Appeal Decision

Appeal A: Appeal Ref: APP/R5510/D/21/3275139 134 Long Lane, Hillingdon UB10 0EH

- The appeal is made under section 78 of the Town and Country Planning Act 1990 against a refusal to grant planning permission.
 - The appeal is made by Mr Sarabdeep Lotay against the decision of the Council of the London Borough of Hillingdon
 - The application Ref 74860/APP/2021/1122, dated 21 March 2021, was refused by notice dated 10 May 2021.
 - The development proposed is the erection of a part two storey, part single storey side and rear extension.
-

Appeal B: Appeal Ref: APP/R5510/D/21/3275140 134 Long Lane, Hillingdon UB10 0EH

A103

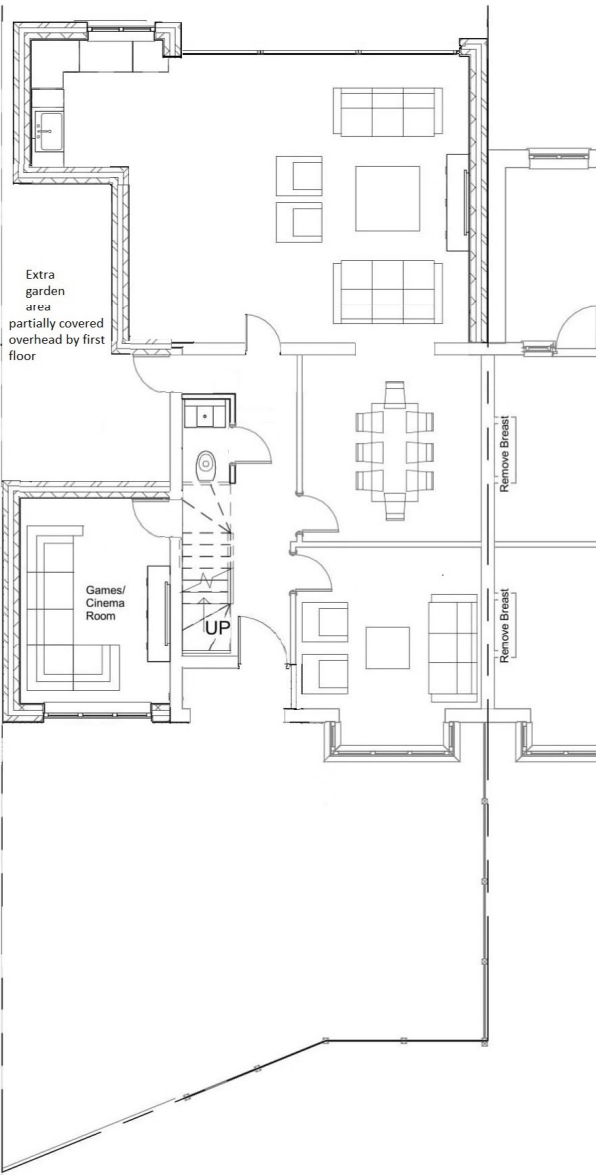
6. For Appeal A, the proposed single storey side extension would have parts of its flank wall being erected adjacent to the shared boundary with No. 136. There would be a gap of around 6 metres where the flank wall would be set back to create a partially covered garden area. The height of the proposed flank wall would be around 3 metres closest to the rear elevation of No. 136 but it would only project about 1 metre beyond this neighbouring dwelling's side/rear extension. Beyond the gap the remainder of the proposed flank wall would be circa 2.1 metres high and possess a sloping roof with a ridge height of approximately 3 metres. The roof of the proposed ground floor extension would project above the existing fence.

7. Although the appellant has sought to address the previous Inspector's concerns, the proposed single storey addition to the lounge would still be visually intrusive and detrimental to the outlook of the occupiers of No. 136 by reason of scale, height and siting. The roof of the proposed extension would be seen from the rear windows, including the kitchen window, and the rear garden of No. 136 which is at a lower ground level. This unacceptable visual intrusion associated with the single storey extension would be accentuated by its close association with the bulk of the flank wall of the first floor side addition.

8. Further, and although not a reason for this appeal to fail, the design of the proposed side extension for Appeal A would be contrived and would not reflect the general form and design of the property, even as approved to be altered. As such, it would not represent high quality design of the type sought by the National Planning policy Framework and adds to the unacceptable harm identified.

A103

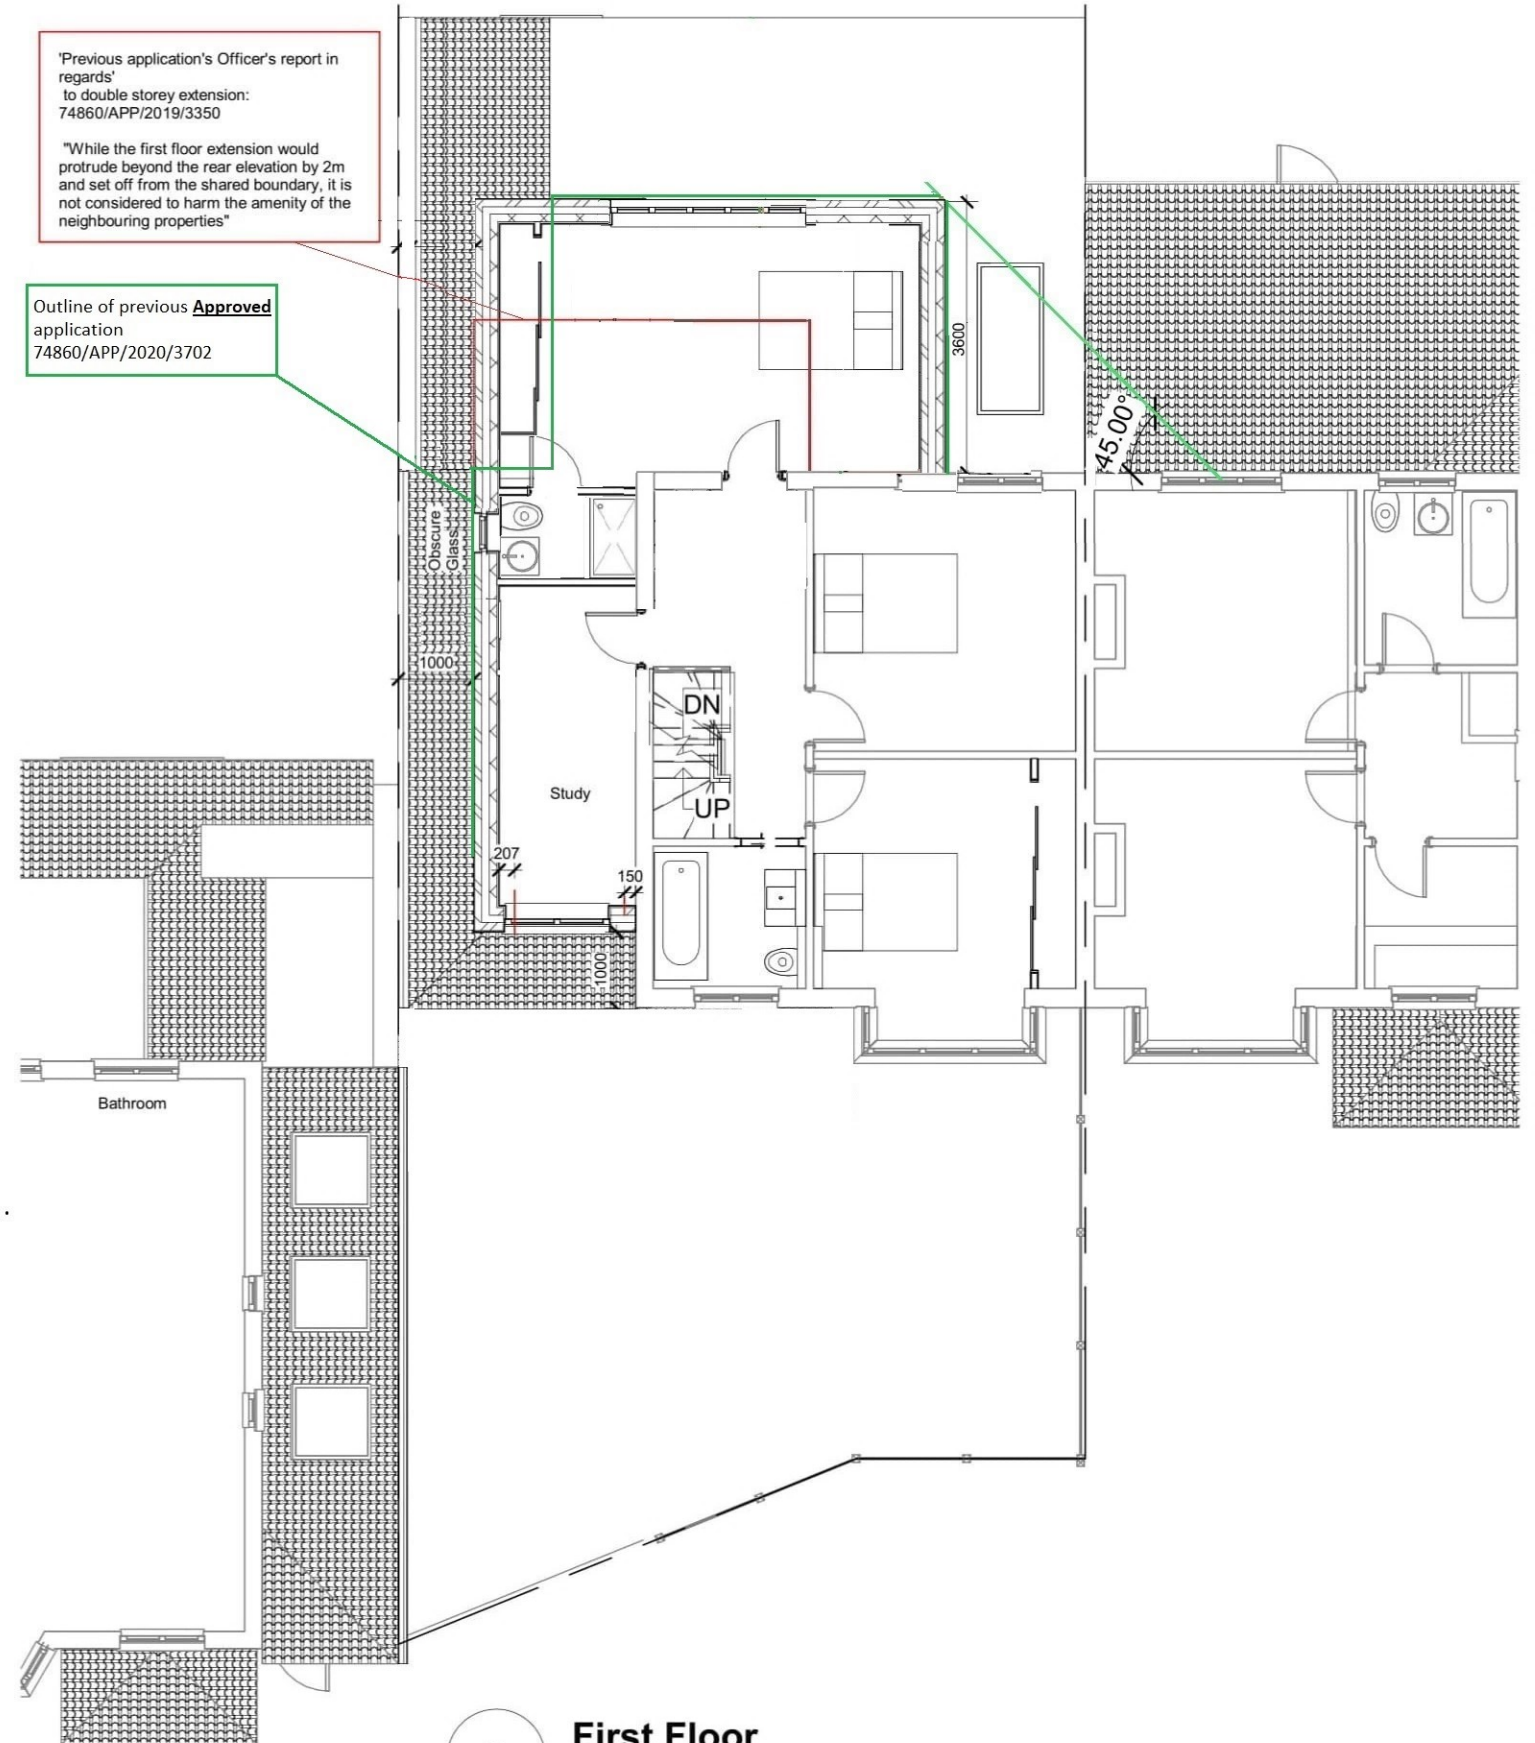
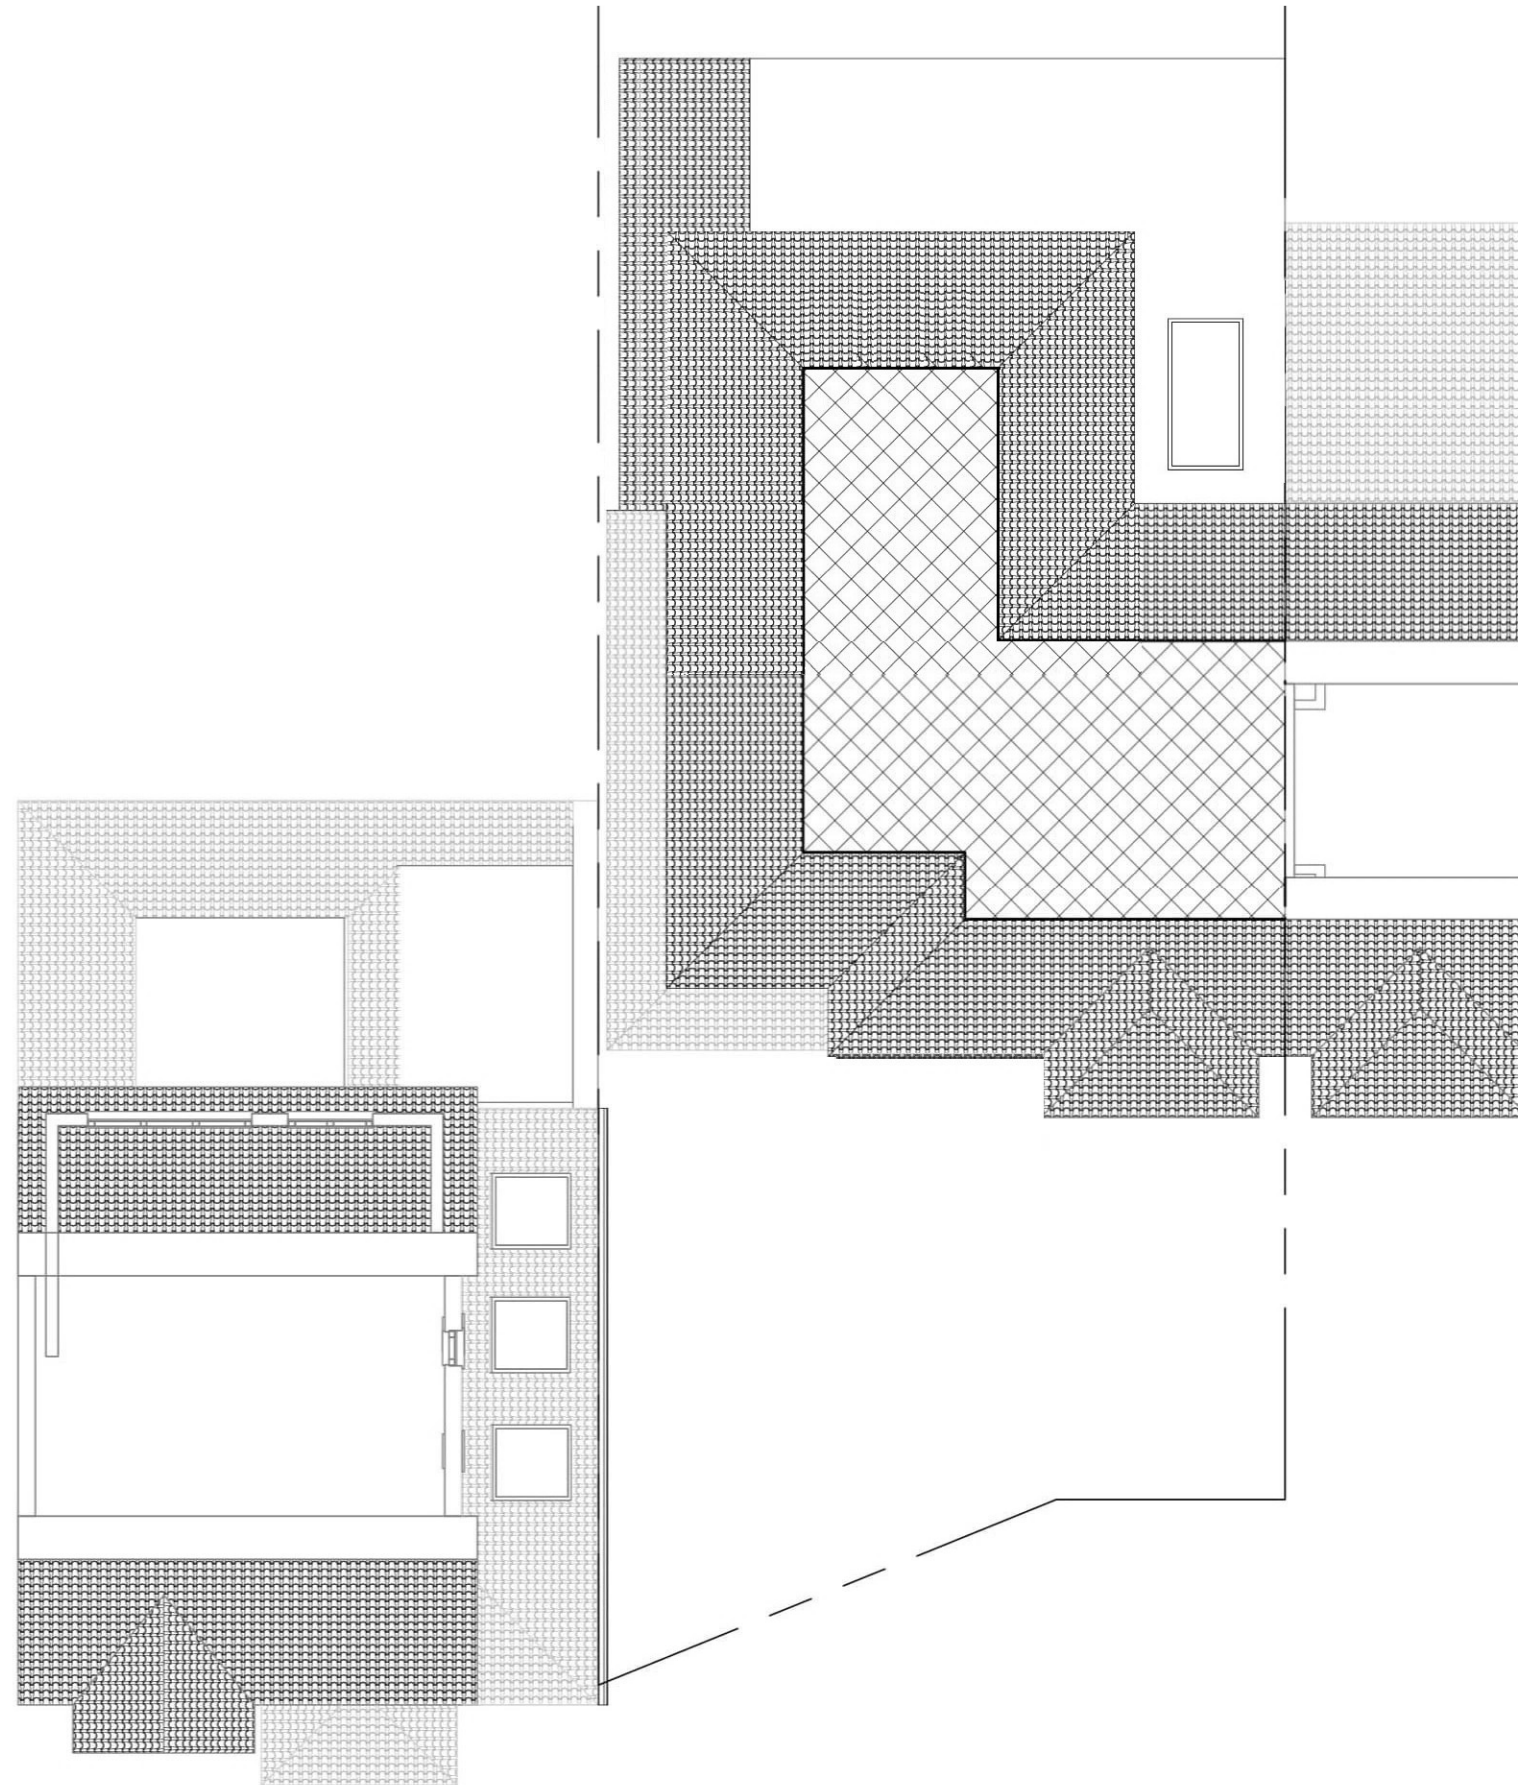
10. For Appeal B, the proposed flank wall would be sited adjacent to the shared boundary with No. 136 and would have an eaves height varying between 2 and 2.5 metres. The side extension would have a sloping roof with a ridge height of approximately 3 metres. Part of the flank wall and the roof of the proposed ground floor extension would project above the existing fence. In combination, the siting, height and length of the single storey flank wall and associated pitched roof would result in an unacceptable visual intrusion for the occupiers of No. 136.

11. Further, for Appeal B the outlook of the occupiers of No. 136 from their garden and the rear windows, in particular the kitchen window, would be dominated by built development close to the boundary rather than having the relief offered by the approved schemes whereby the approved flank walls would be set back from the shared boundary. The unacceptable visual intrusion associated with the single storey extension would be accentuated by its close association with the bulk of the flank wall of the first floor side addition.
